**Application by East Yorkshire Solar Farm Limited for East Yorkshire Solar Farm
The Examining Authority's second written questions and requests for information (ExQ2)
Issued on 1 August 2024**

ExQ2: 1 August 2024

Drawing Title  
**LAND PLAN SHEET 5 OF 22**

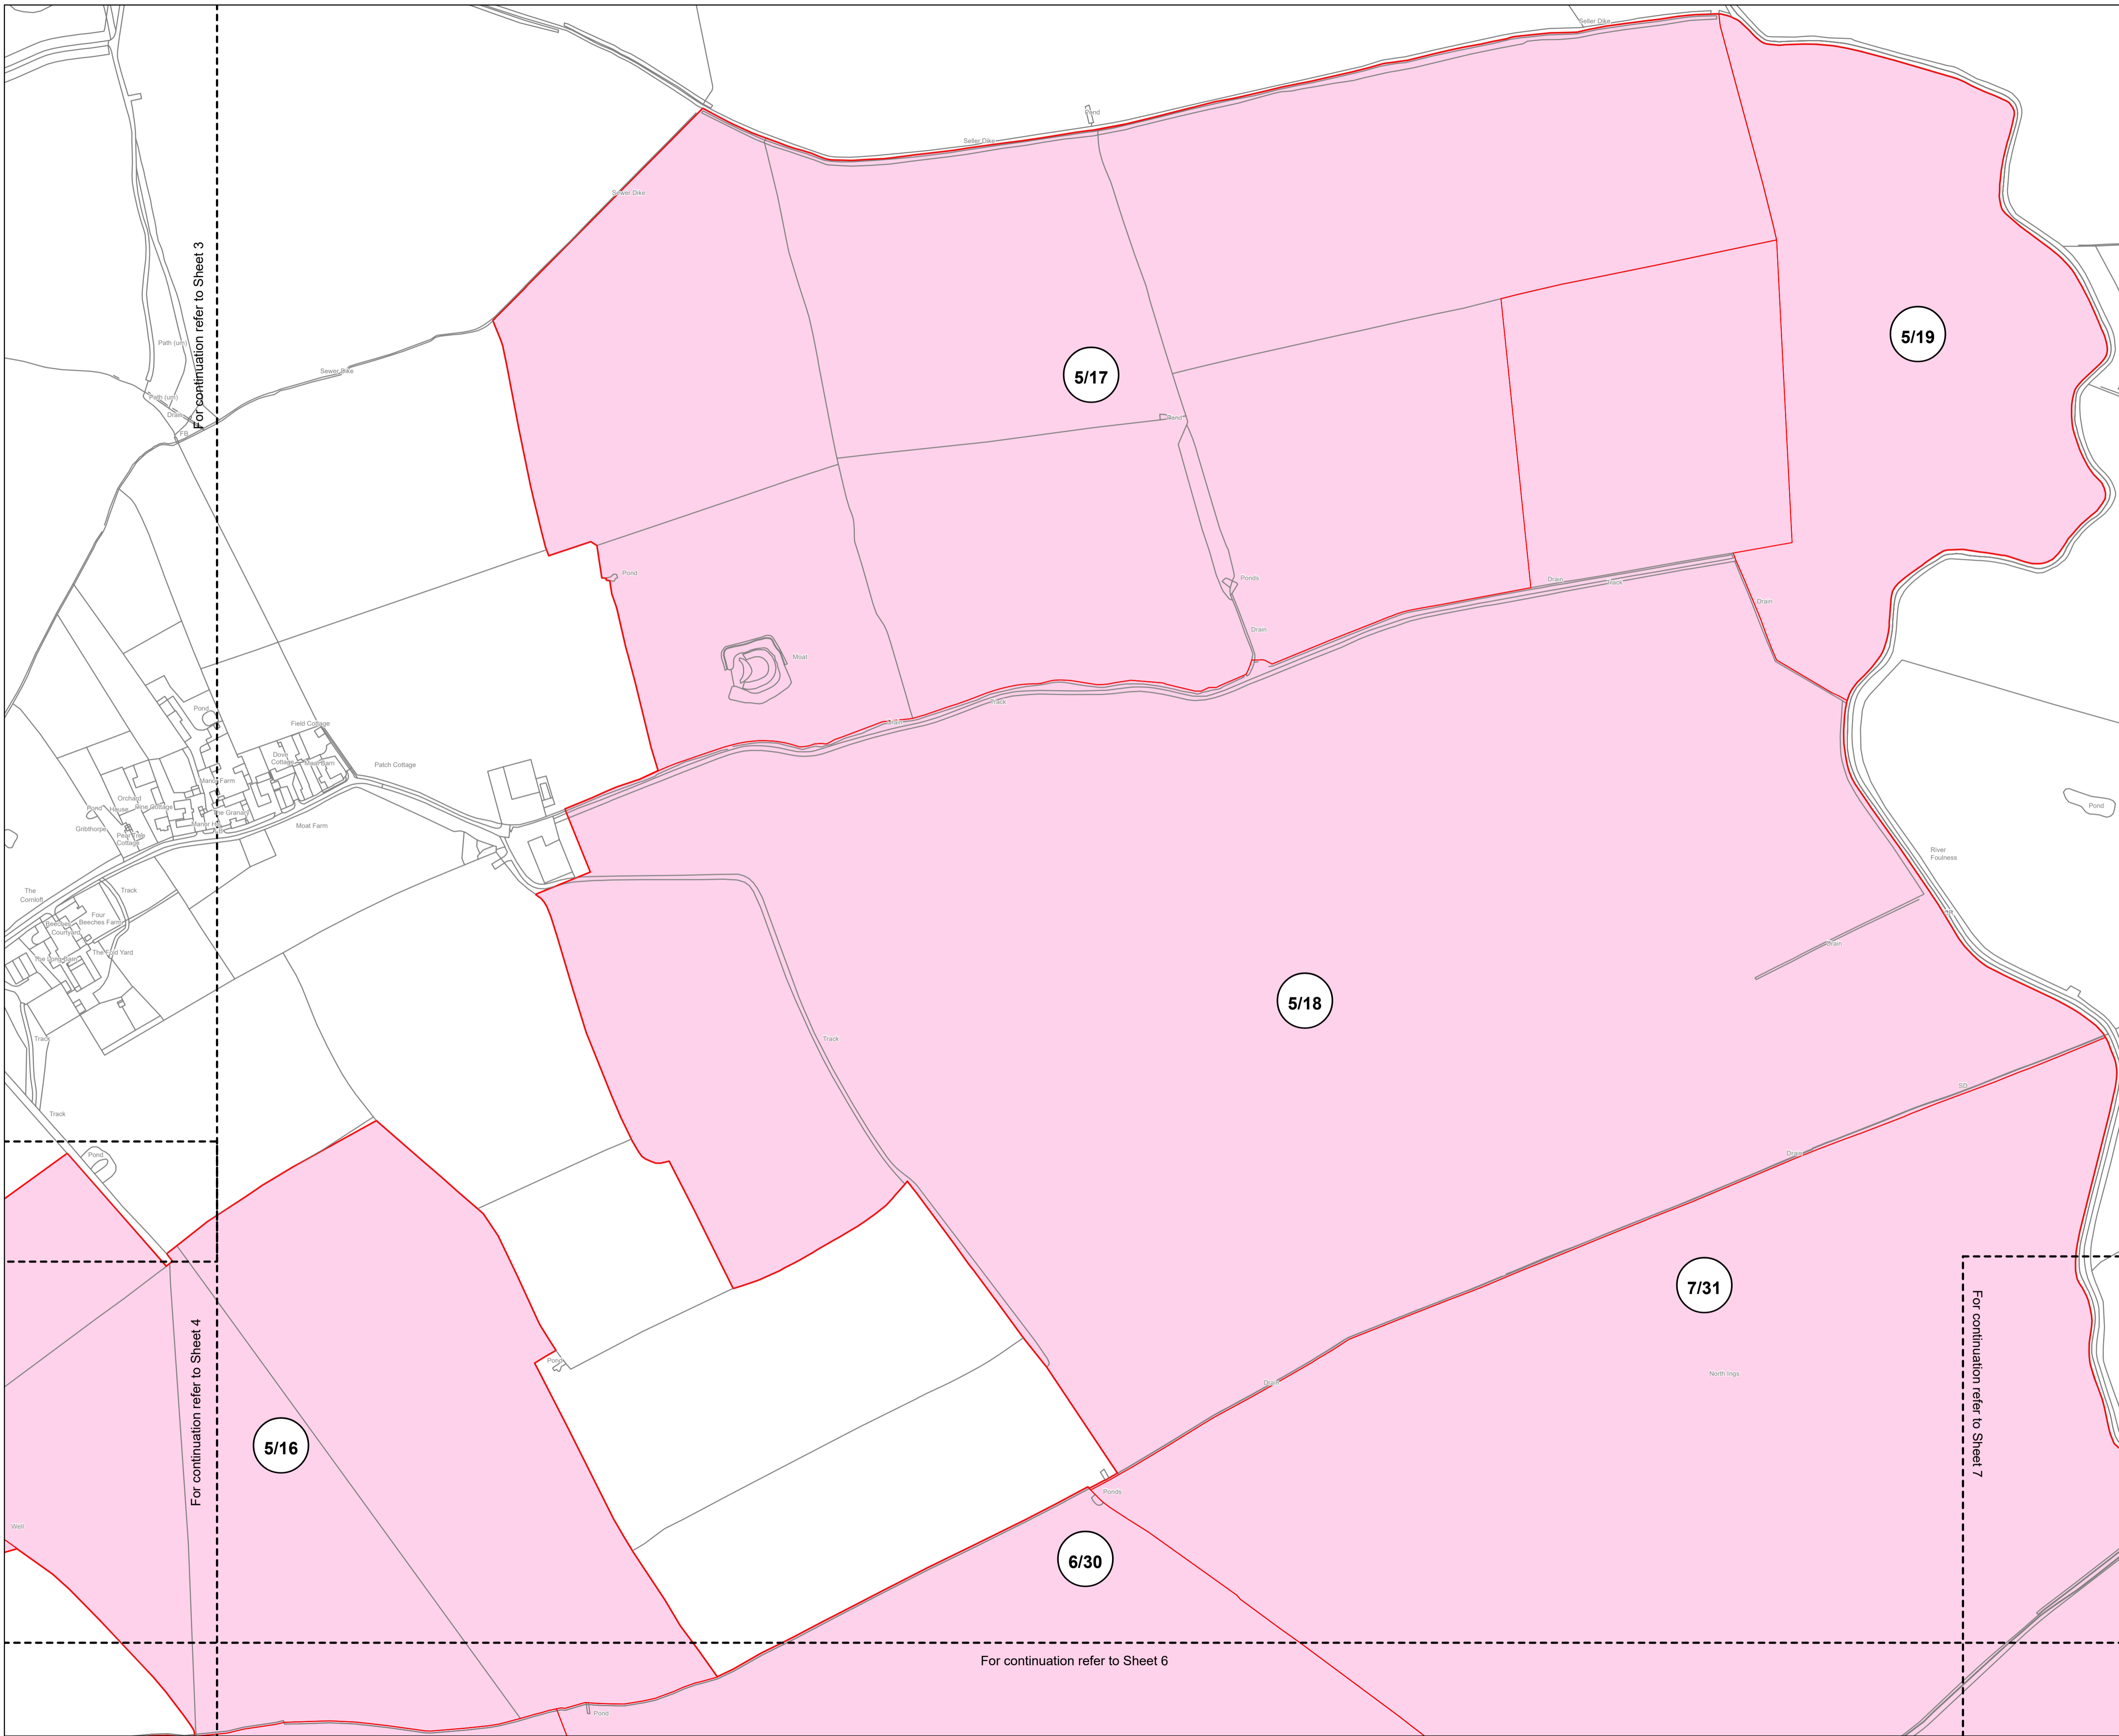
Q3.0.2	The Applicant	<p>Plots 5/17, 5/18 and 5/19 (Parkin, Laverack, Saunders. It was established at Compulsory Acquisition Hearing 1 (see [REP3-034]) that progress on negotiations on these plots was contingent on agreement with NE regarding the proposals for mitigation at Areas 1g and 1h. Please provide an update on negotiations having regard to your response to Q2.0.2 above.</p>
Q3.0.3	The Applicant	<p>The Applicant’s response to submissions received at Deadline 2 [REP3-033] includes information on the funding of the proposal (in response to a submission from Sir David Davis MP).</p> <p>(a) Paragraph 2.3.3 of the funding statement [APP-022] states that <i>“the letter of support at Appendix 1 confirms that PNE can fund the total of the construction and compulsory acquisition costs for the Scheme.”</i> However, section 4 of the letter states <i>“This letter of support does not require us (PNE) to fund the Project, nor does it represent or create any legal obligations and none shall be implied”</i>. Please clarify the apparent contradiction between these statements and confirm the source of funding for the project.</p>
